From: Amanda Scholes on behalf of Planning.Responses
Sent: 25 November 2020 11:30
To: Planning Scanning
Subject: FW: BE/92/20/DOC

From: Sarah Burrow <Sarah.Burrow@arun.gov.uk>
Sent: 25 November 2020 09:14
To: Maria Tomalova <Maria.Tomalova@arun.gov.uk>
Cc: Roger Spencer <Roger.Spencer@arun.gov.uk>
Subject: RE: BE/92/20/DOC

From: Maria Tomalova <Maria.Tomalova@arun.gov.uk>
Sent: 24 November 2020 18:29
To: Sarah Burrow <Sarah.Burrow@arun.gov.uk>
Subject: BE/92/20/DOC

DRAWING TITLE
PROPOSED RESURFACING OF SITE ACCESS

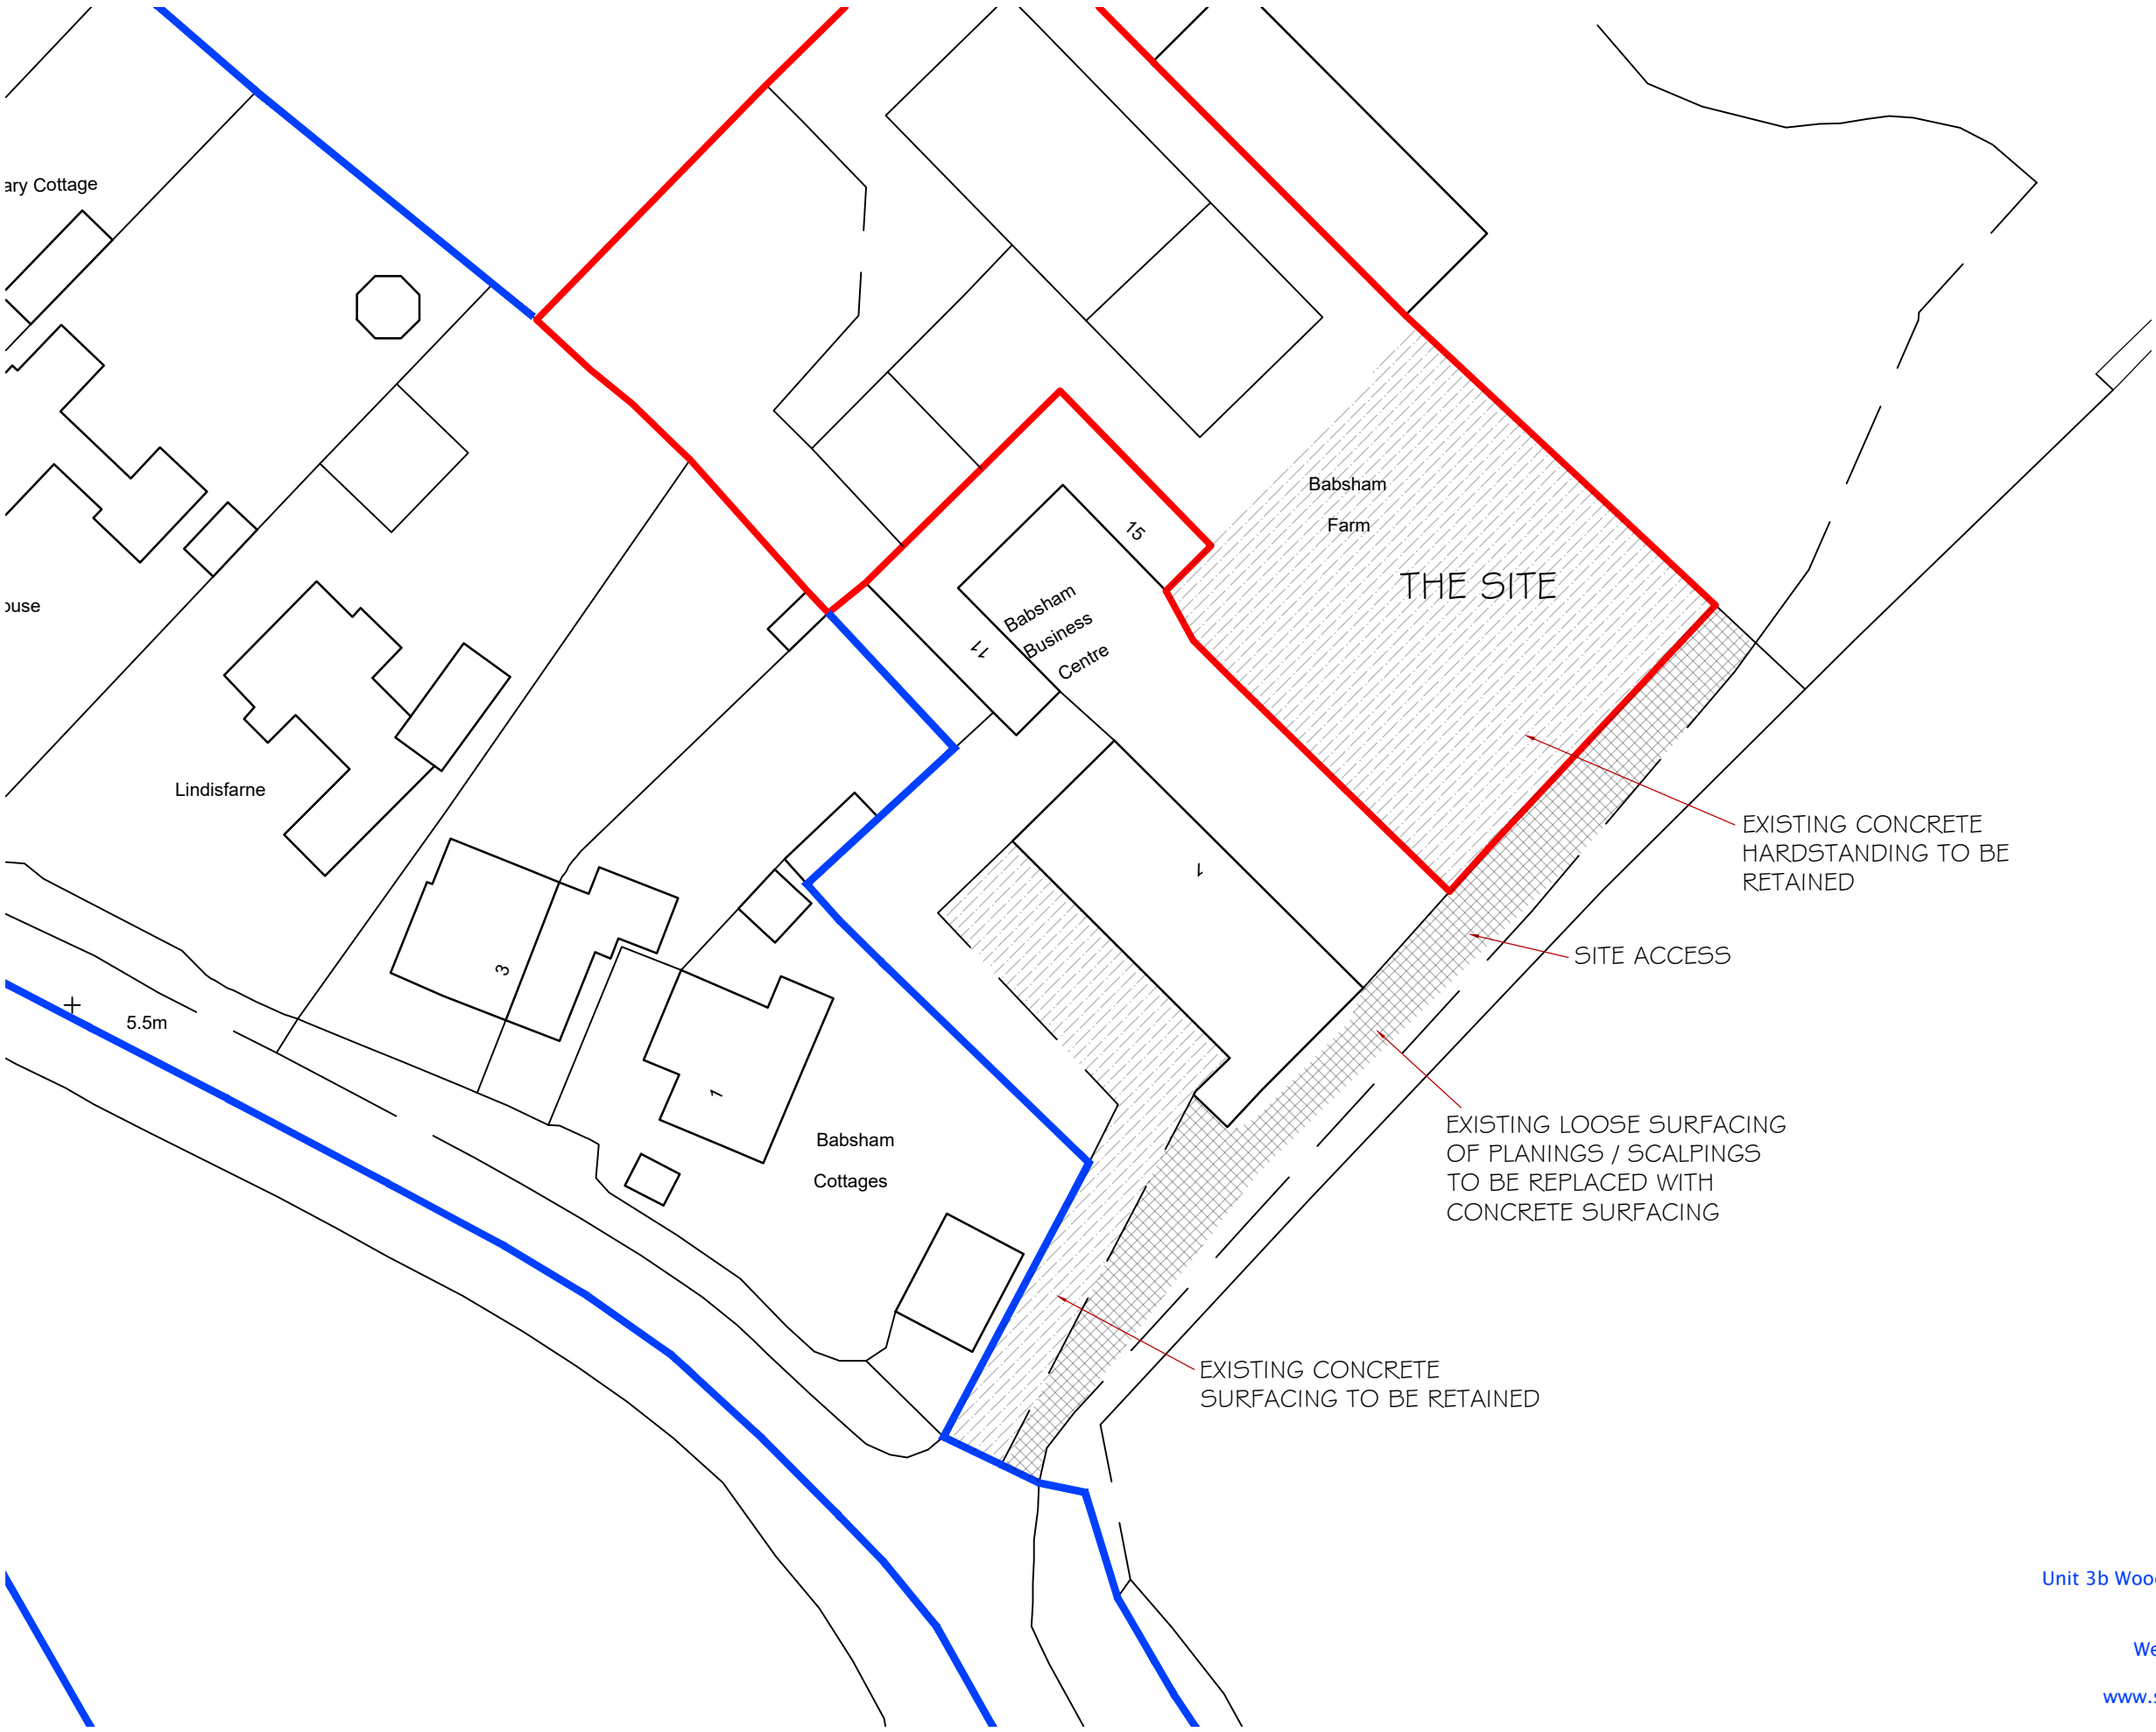
I have taken a look at the documents as this is not a case I am familiar with. From what I can tell the majority of the site is existing hardstanding and they are proposing formalising the existing access of loose material to concrete surface/tarmac.

In an ideal world we would expect the hard surface to be designed in a permeable construction. However, given the size and location of the site and our current resourcing I doubt that there is appetite to follow this up or scrutinise it further.
